**STATE SIGNIFICANT DEVELOPMENT:
Section 96(2) Modification Application**

**Sydney International Convention, Exhibition and
Entertainment Precinct (SICEEP), Darling Square
(formally The Haymarket), Darling Harbour**

SSD 5878 MOD2

Environmental Assessment Report
Section 96(2) of the *Environmental Planning and
Assessment Act 1979*

7428A MCD AR D202
1:1000 @ A3
0 5 25m

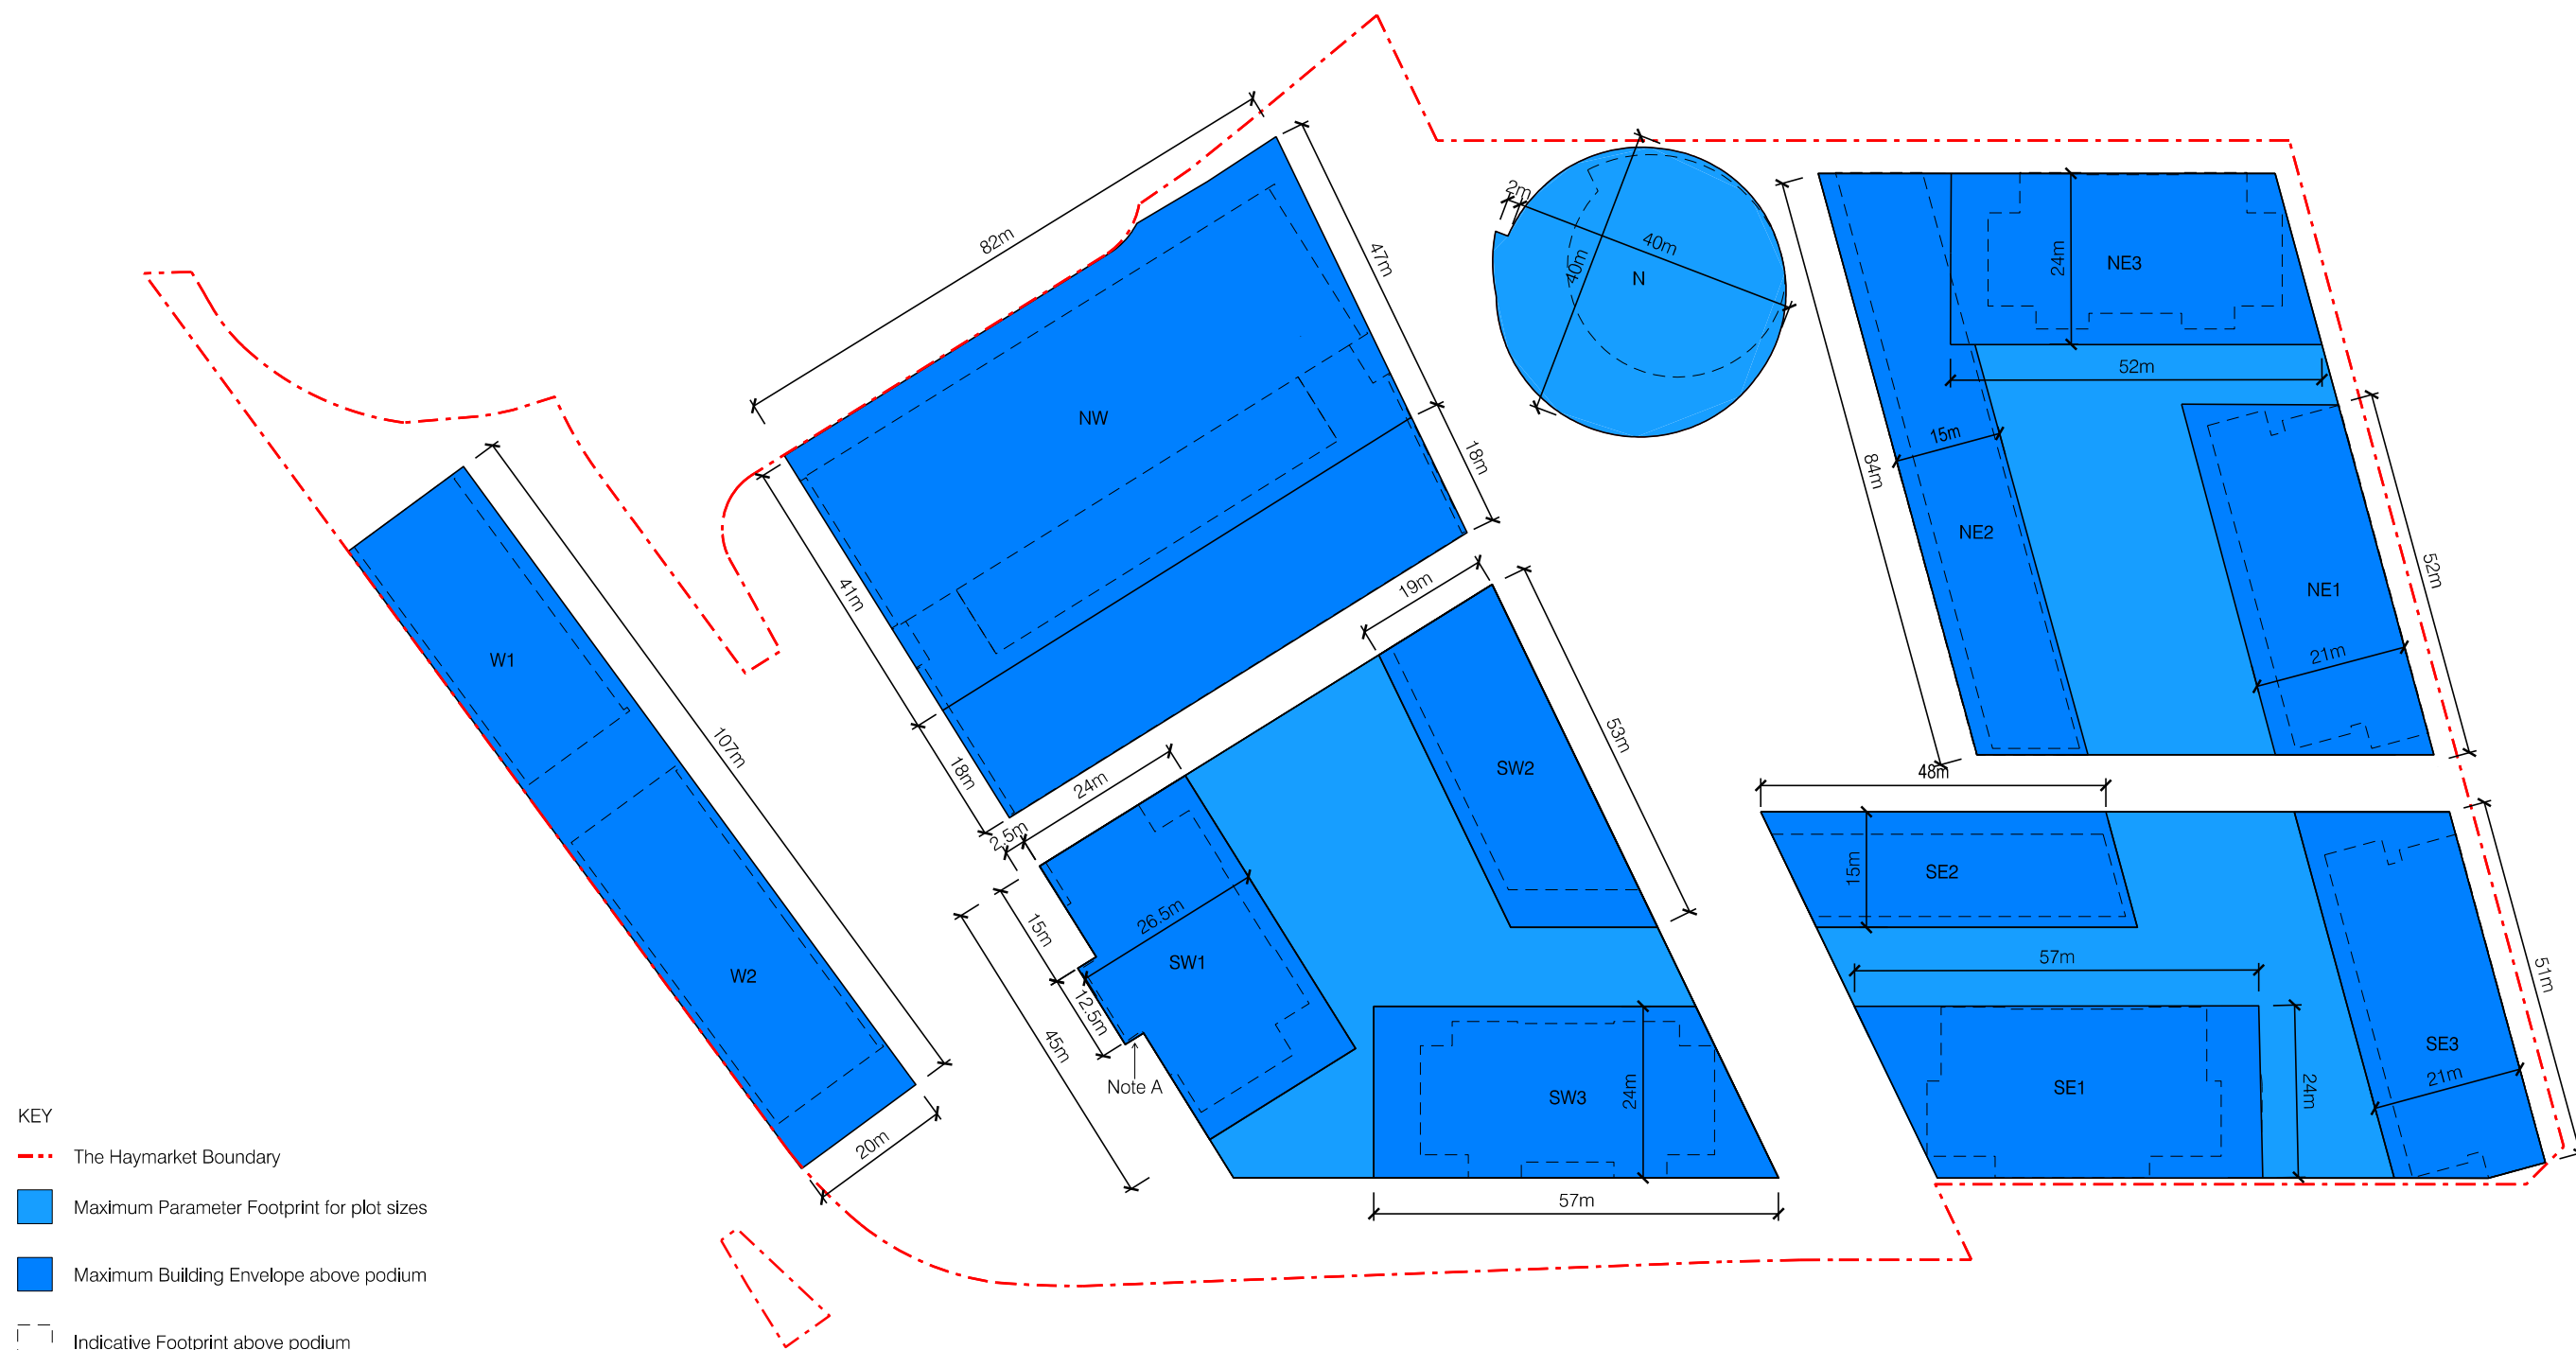
The modification seeks to reduce this separation between the North and North West Plot building envelopes to 19 metres at ground floor level, 13.4 metres at public stair/canopy level and 16 metres at upper levels (refer to **Figures 5** and **7**). The Department notes this alteration results in the North Plot building envelope projecting into the 20 metre width of the boulevard and therefore interrupts the consistent north/south view-line along the boulevard.

However, the Department is concerned the encroachment of the North Plot building envelope into the boulevard at the lower levels (up to a height of about 6.5 m above ground level, as shown on **Figure 7**) would materially impact the integrity of the design quality and function of the boulevard. In particular, the wrapping stair structure at this lower level would impact upon north / south views along the boulevard for pedestrians and has the potential to impede the intended open sense of pedestrian connectivity afforded by the approved boulevard space (refer to **Figure 8 and 9**).

The Department therefore recommends a condition requiring amended drawings and Design Guidelines showing an uninterrupted 19 m building separation width for the boulevard between the North Plot and North West Plot buildings up to height of 6.5 m.

Parameter Plan 04: Drawing no MCD AR D205 Minimum building envelope separation

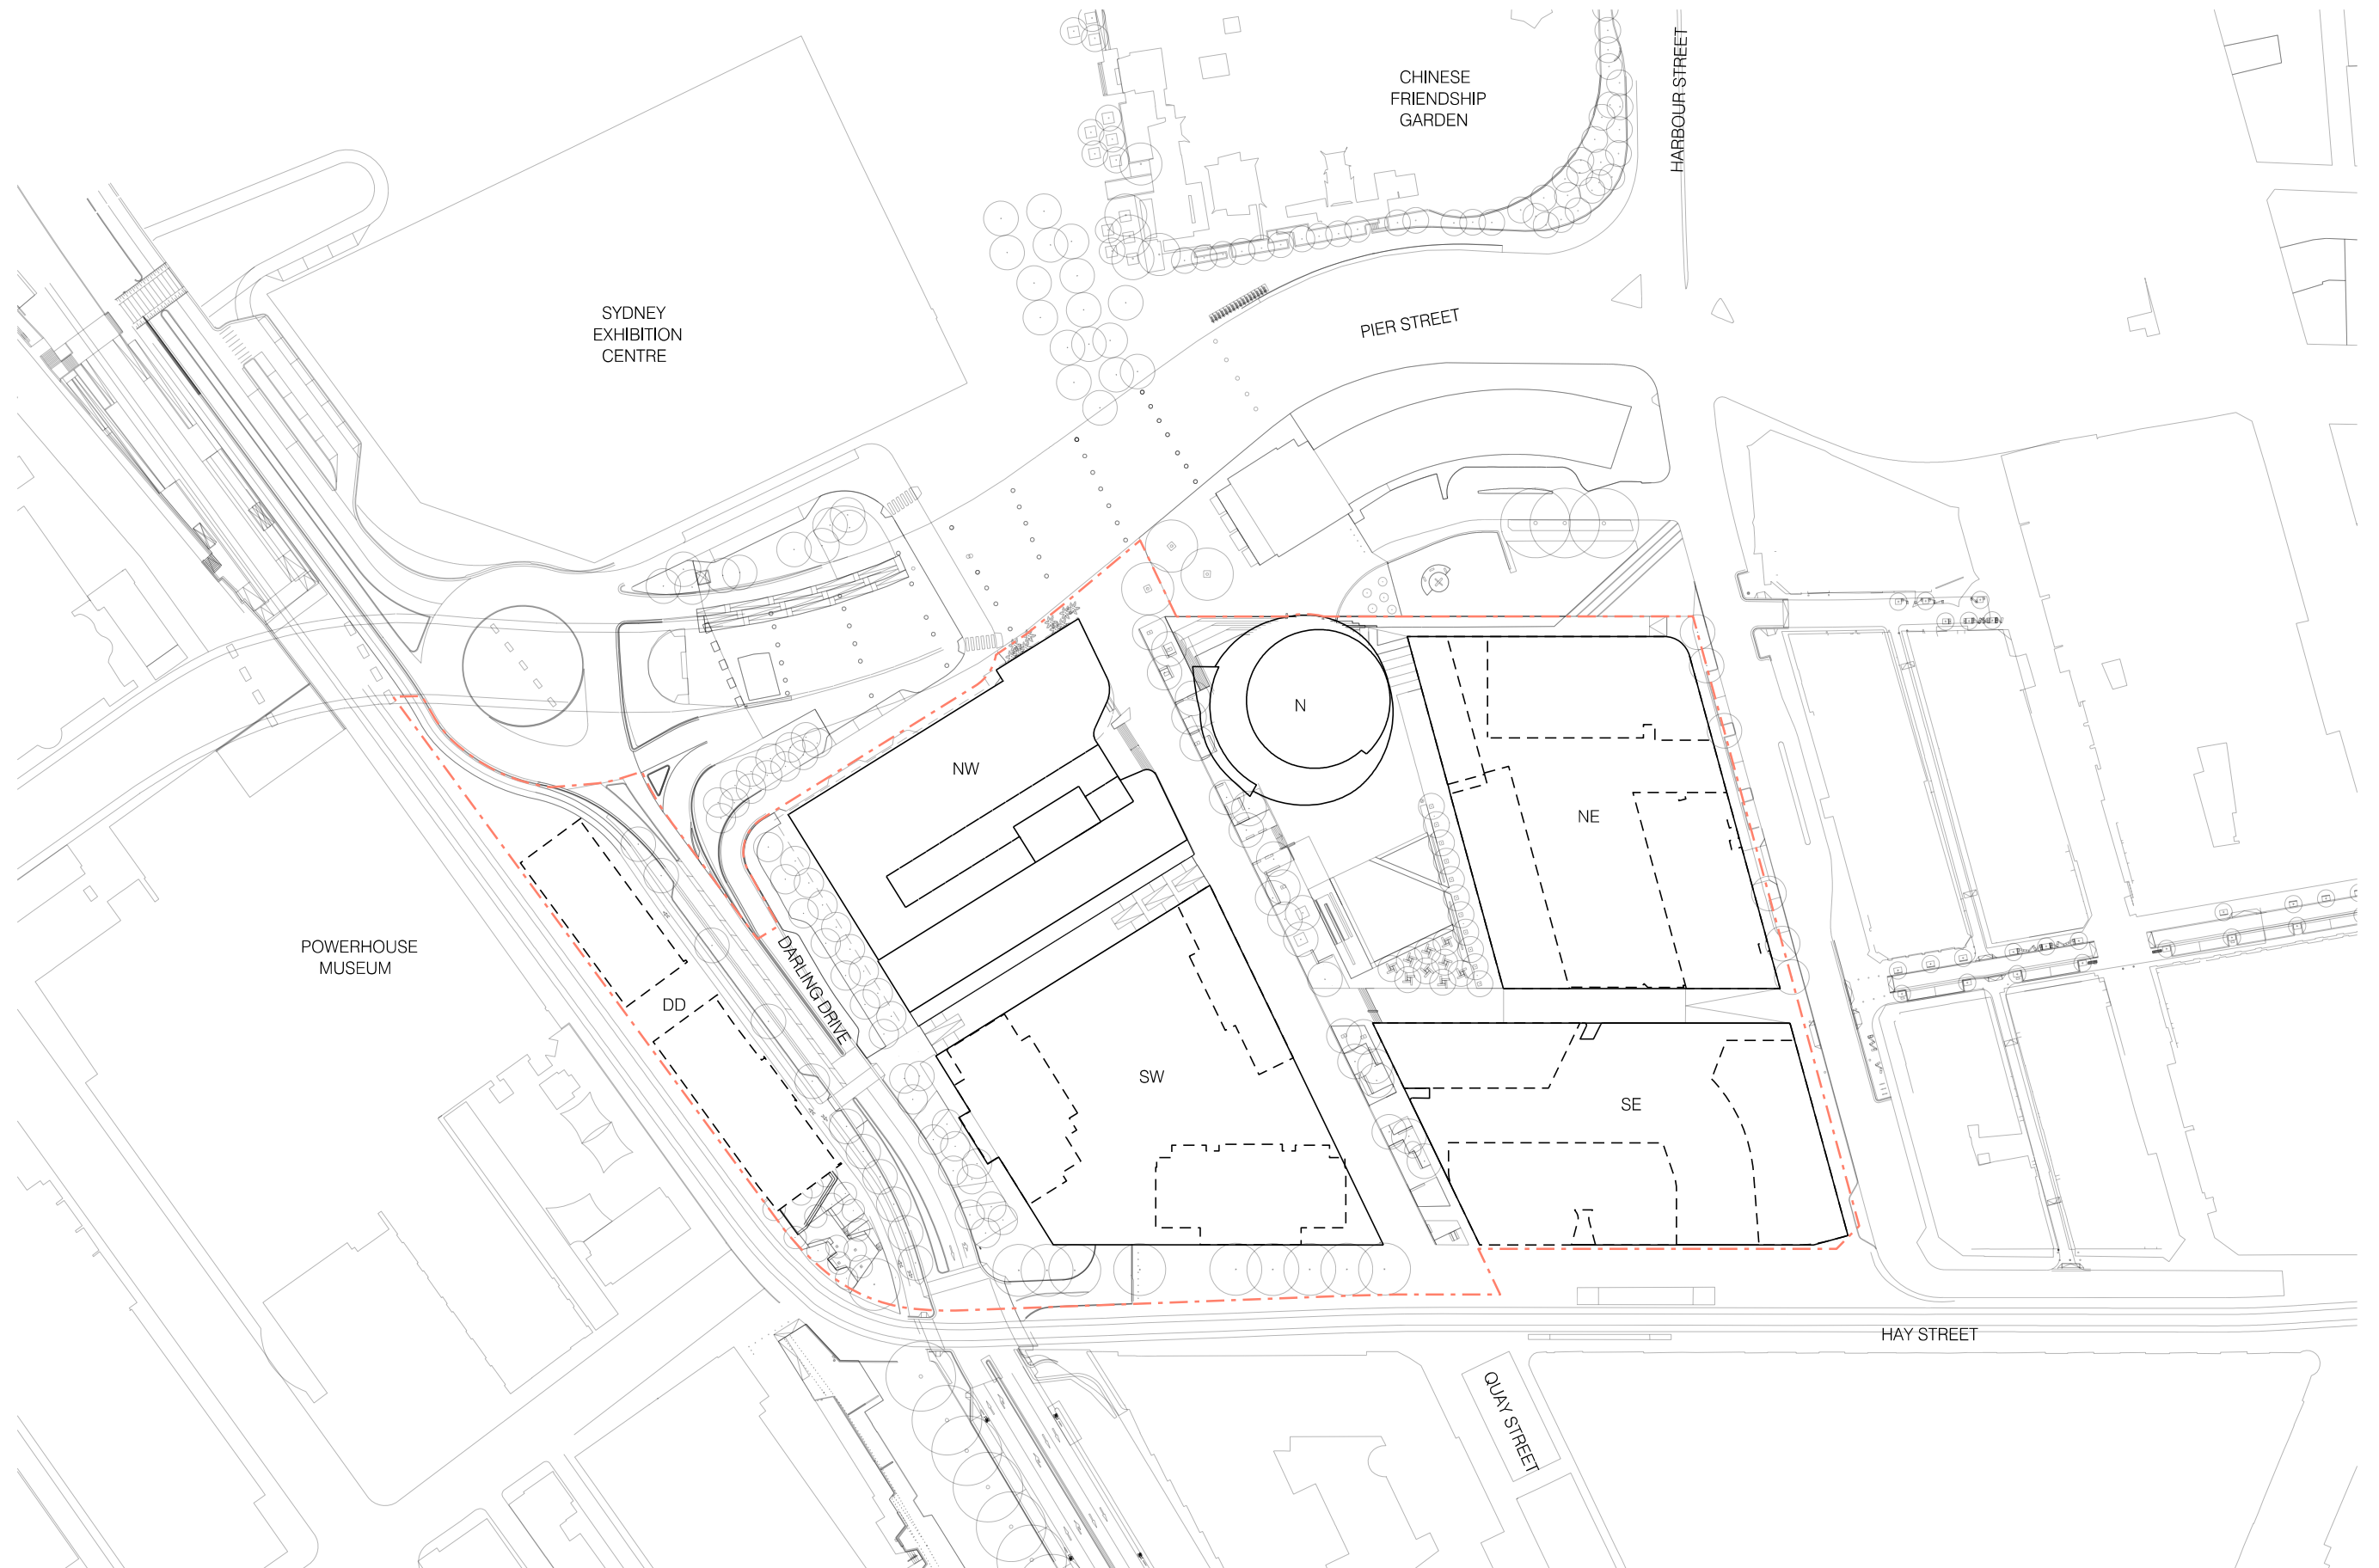
The proposed widening of the North Plot building envelope to the east (to accommodate the timber wrap) will result in it being 1.5 m closer to the North East Plot residential podium at its closest point. The Department considers this change is acceptable as:
